Ref: 6/2024/2170/FULL  
Date: 16/12/2024

## HISTORIC BUILDINGS AND CONSERVATION ADVICE

### RE: Telephone Exchange Wigmores North Welwyn Garden City AL8 6PH

Built heritage advice pertaining to installation of an aluminium louvre following removal of 2x windowpanes on the first-floor east elevation.

TITLE
PROPOSED & EXISTING ELEVATIONS FOR
WELWYN GARDEN TELEPHONE EXCHANGE

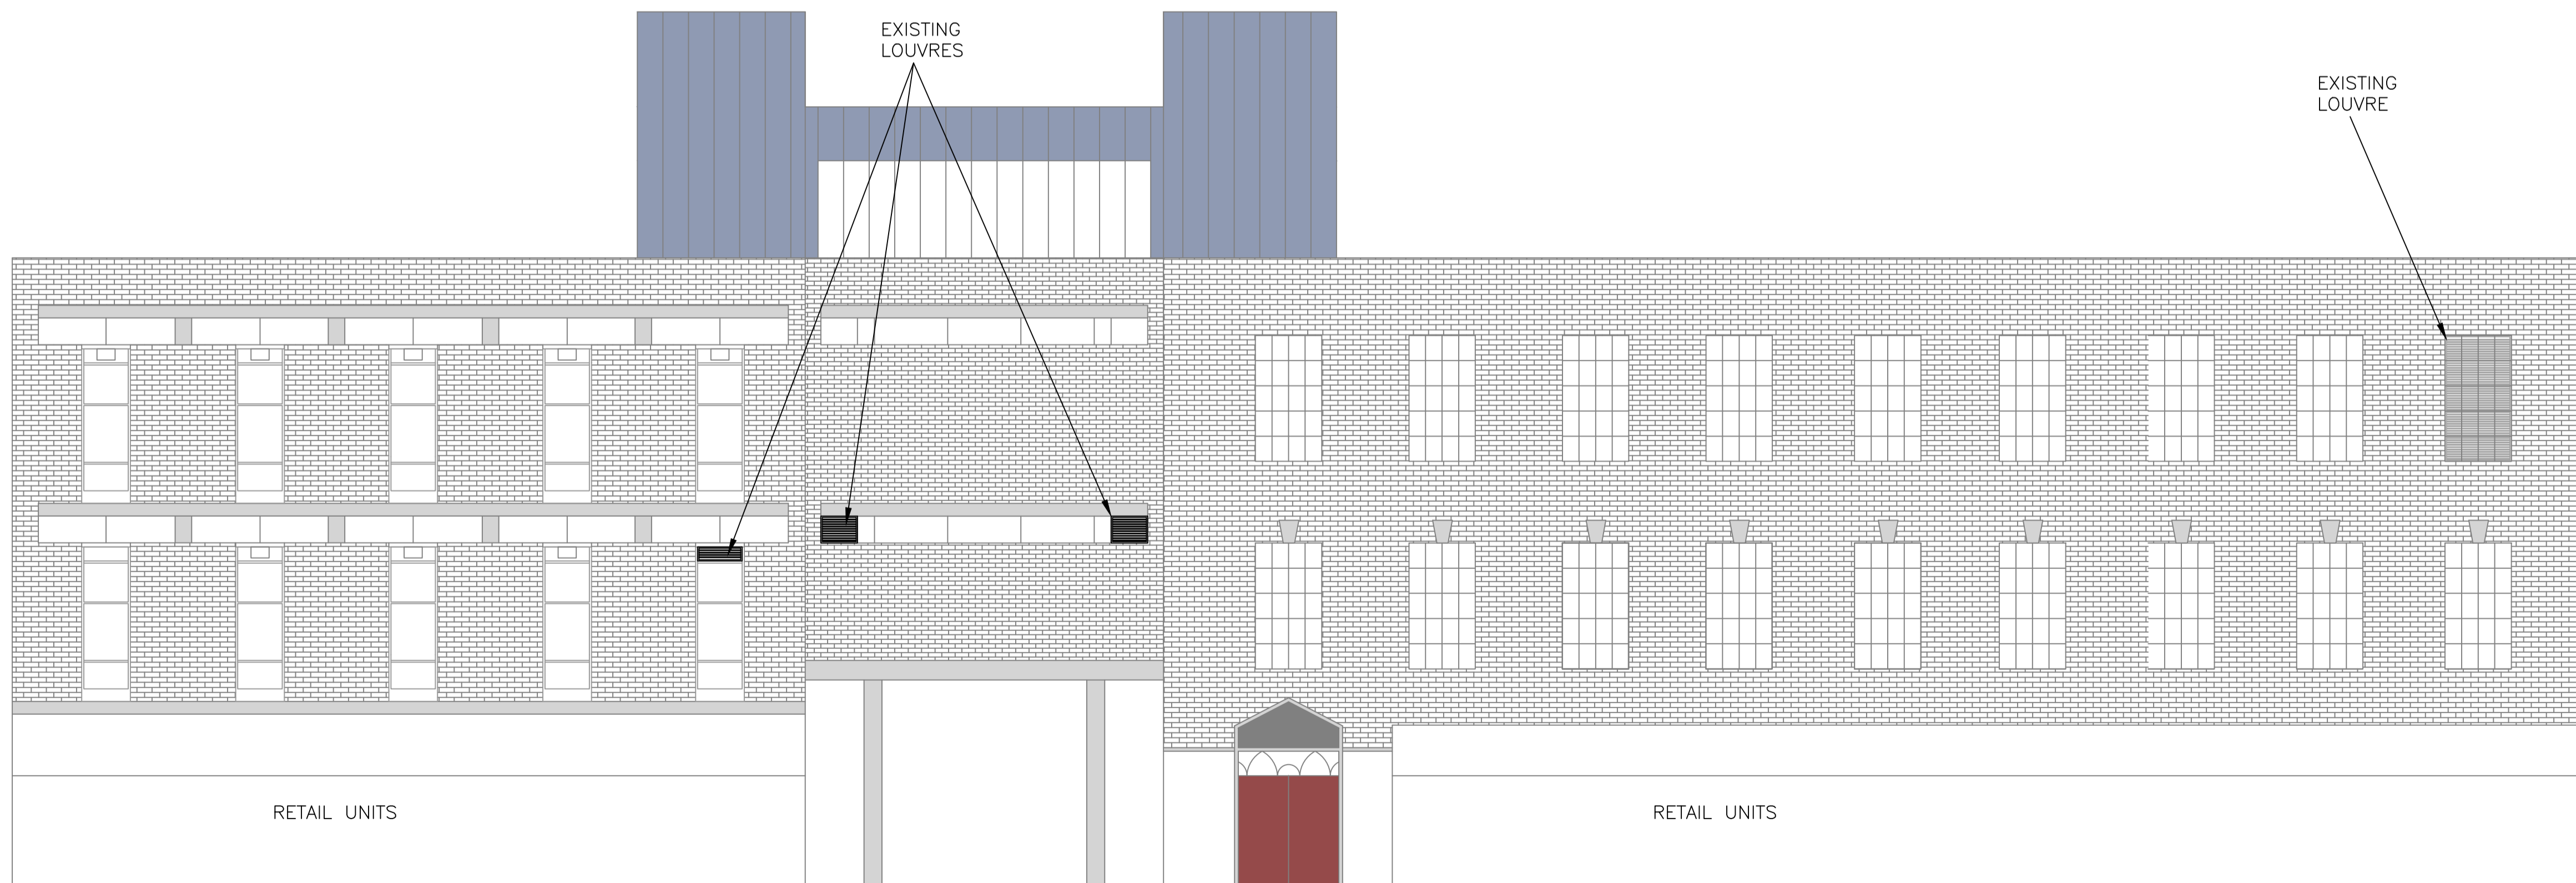
The proposed installation of the louvre would disrupt the very regular and consistent fenestration pattern of the property and introduce an atypical feature to the first floor opening. The uniformity of the fenestration pattern and appearance is a key architectural feature of the Neo-Georgian buildings within the Conservation Area. Although the windows are located in a later extension, it still follows the uniform frontages seen within the original Welwyn Garden City buildings, preserving the character and appearance of the Conservation Area. However, the proposal would erode this key design principle.

The existing louvers are small and in discrete locations. Furthermore, one of the existing louvers to the upper floor window is set behind a frame that mimics the pattern of the window glazing bars which lessens its visual impact upon the streetscene. The proposed louvers would occupy a much larger opening, in a more visually prominent location.

The proposals would fail to preserve the special interest of the listed building, and Section 16(2) of the Planning (Listed Buildings and Conservation Areas) Act 1990 should be considered. With regarding to the National Planning Policy Framework, the level of harm is considered less than substantial making paragraph 215 of the NPPF relevant.
